Walker Reserve, MS-19-004

Please accept the following comments from El Paso County Public Health regarding the 3-lot minor subdivision project referenced above:

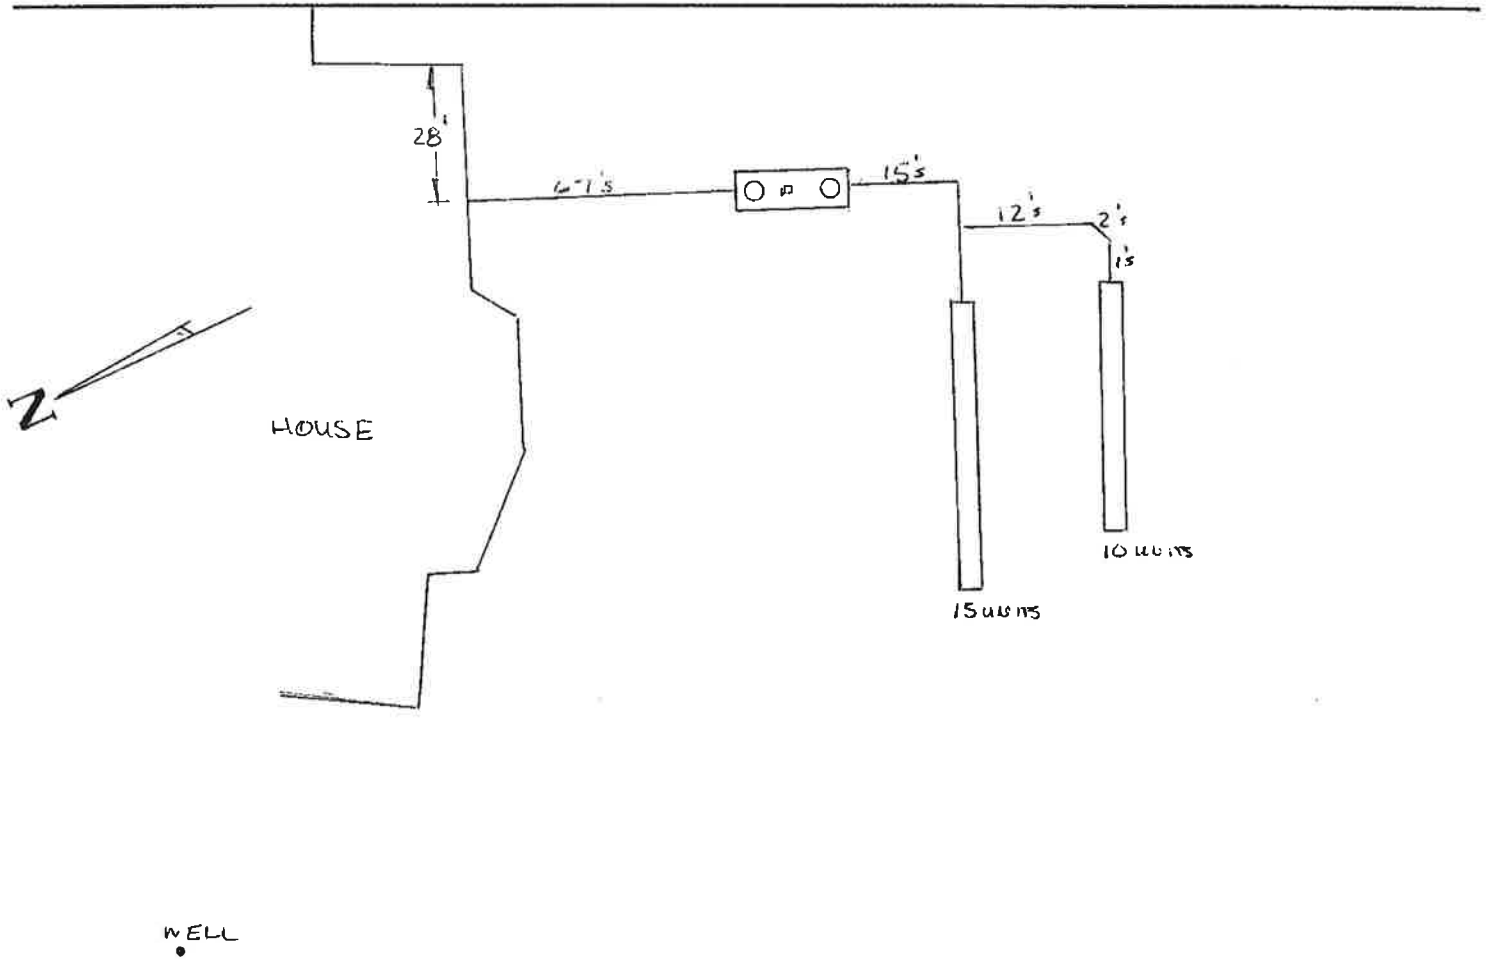
- All components of the 1994 OWTS must be on Lot 3 and meet the current OWTS Regulations minimum horizontal installation setbacks. Based on the 1994 drawing this does not appear to be an issue.
